In response to Applicant's Response to Relevant Representations:

RR-013

RE: REQUEST FOR ADDITIONAL VISUAL RECEPTOR AT LOWWOOD

Figure 7.4 Visual Receptor Location Plan

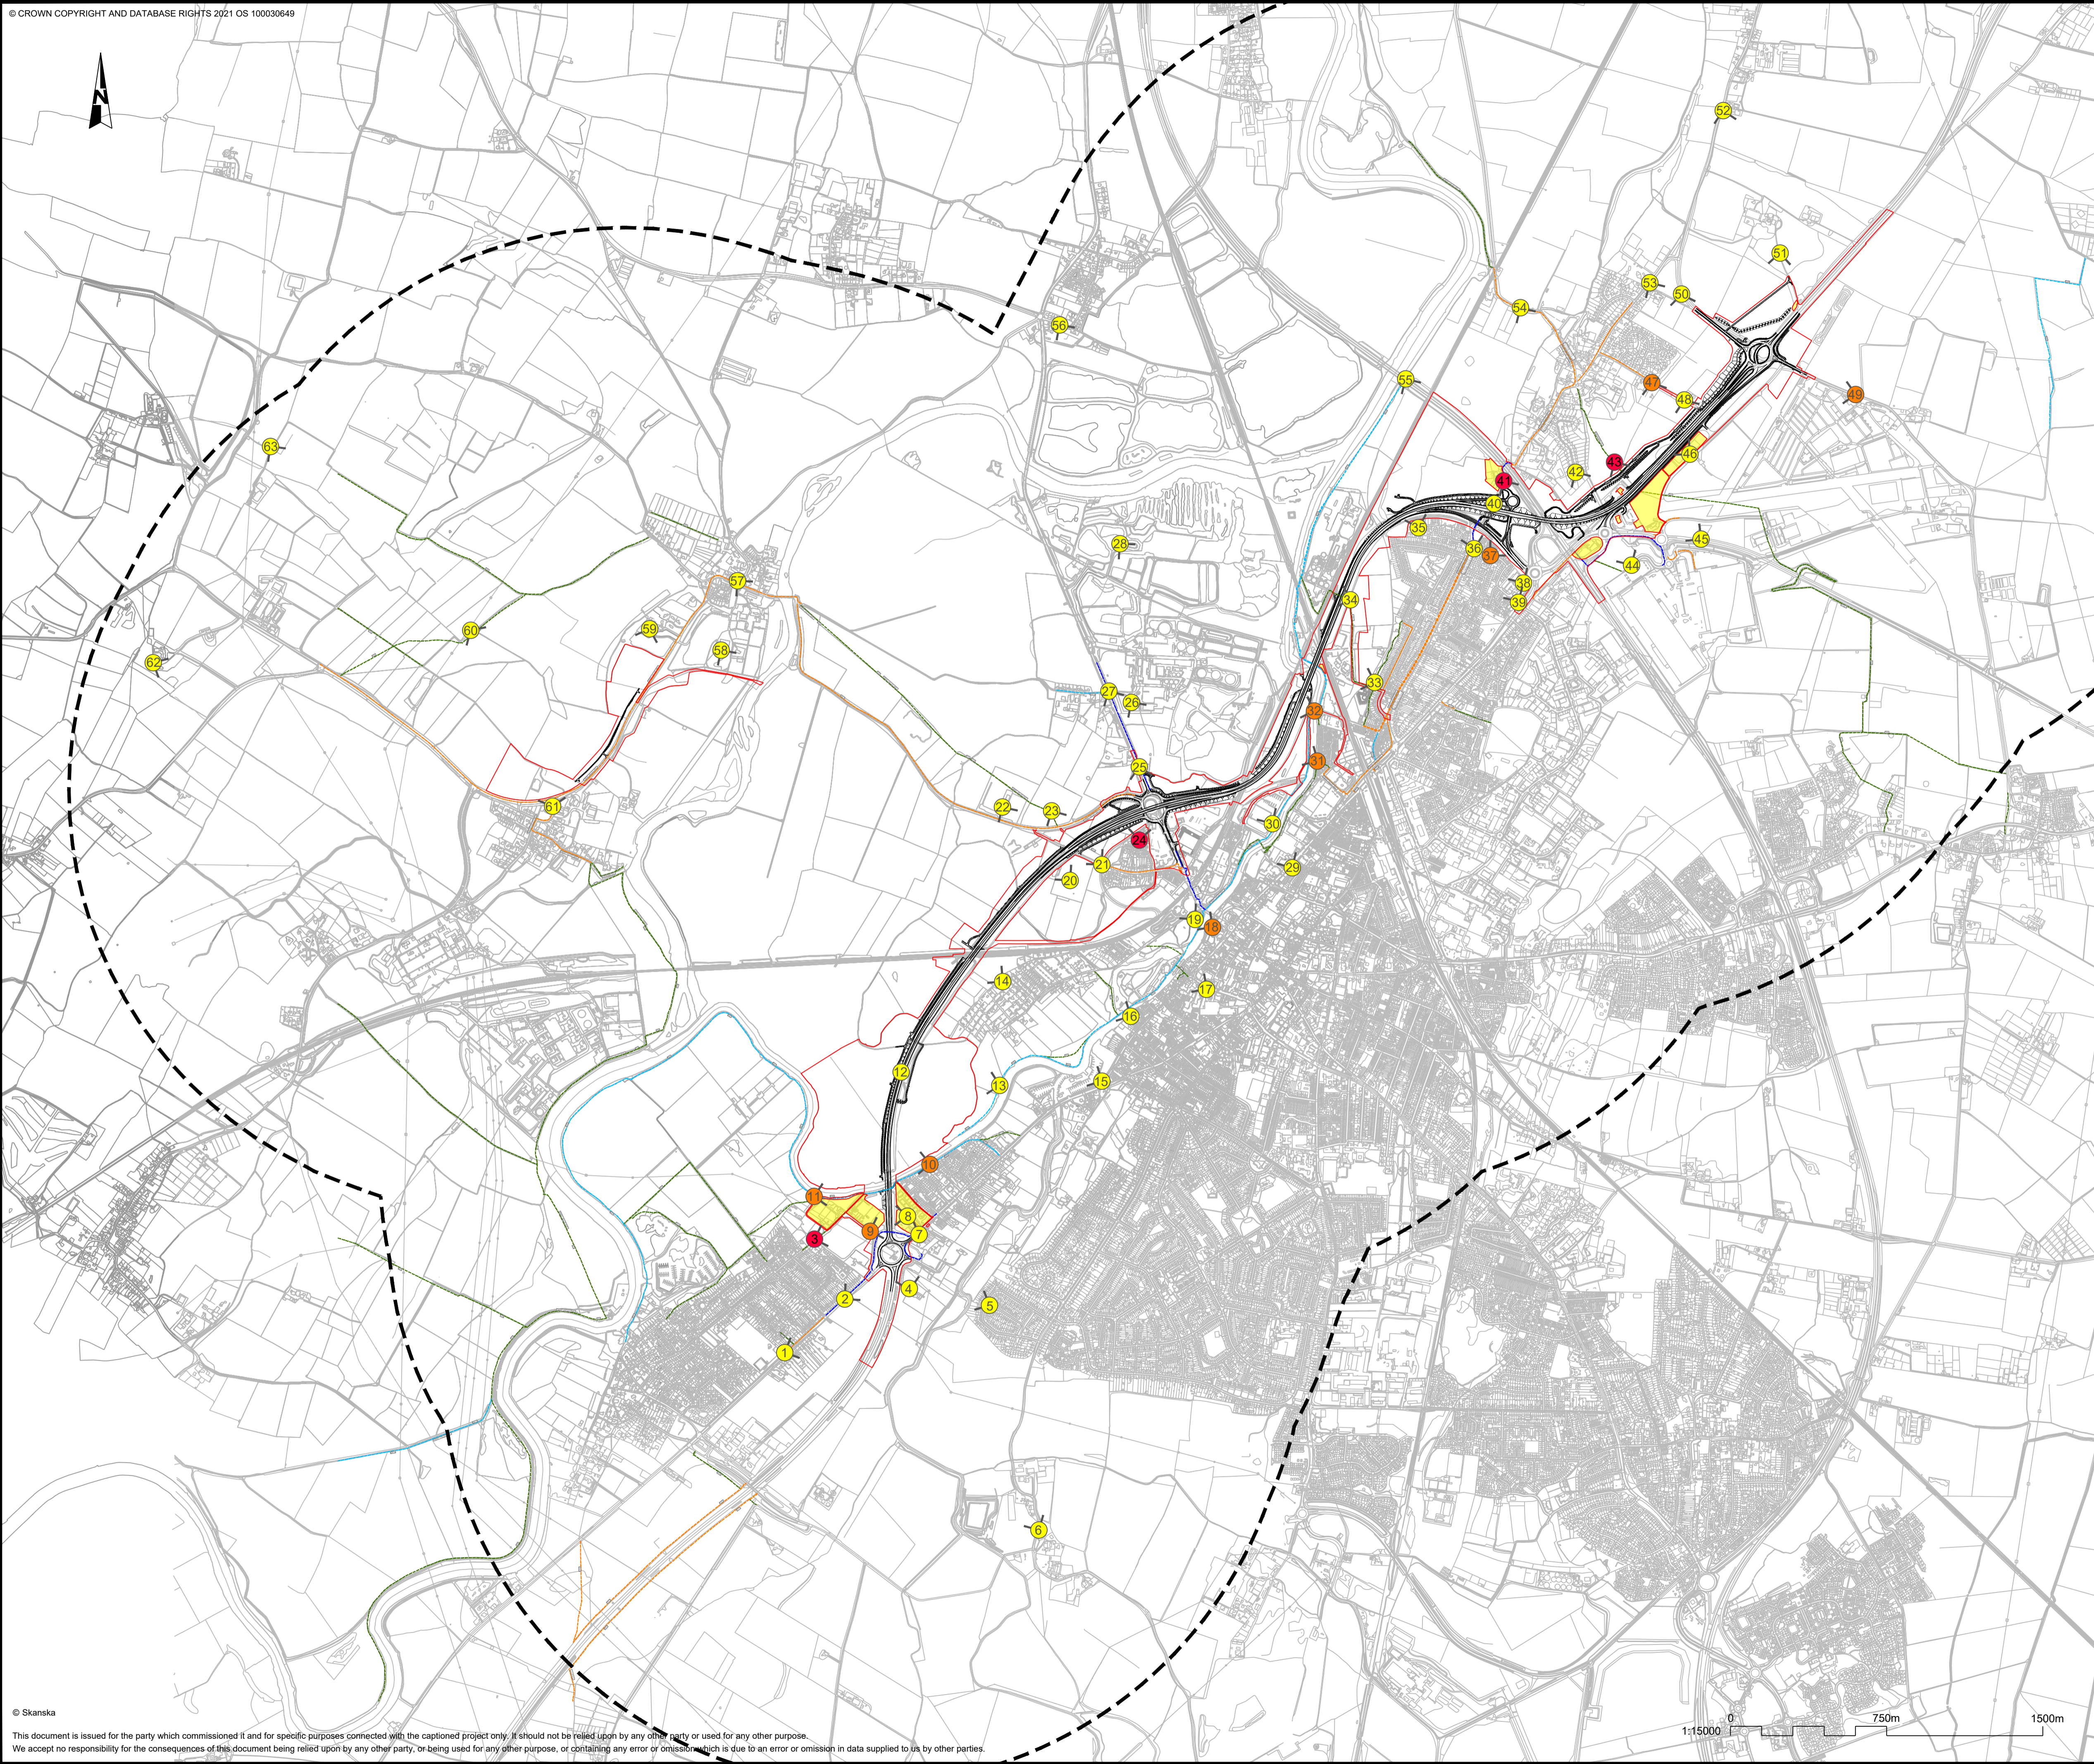
Despite the applicant's comments I still do not believe that the visual impact on Lowwood- Grade II listed building of historical interest- is covered sufficiently in the applicant's reports. Visual receptor number 42 is not suitable for assessing the impact on this property due to its location behind houses on The Spinney. An additional receptor is required further to the SouthWest in the area between Lowwood itself and the Mint Leaf site, or thereabouts. This grade II listed building is the view of the south side of the Winthorpe conservation area and this has not been properly documented. An acknowledgement of the hazard to this location is needed, together with some proposals for mitigation. I welcome the visit from the examination authority now planned on Friday December 6th 2024.
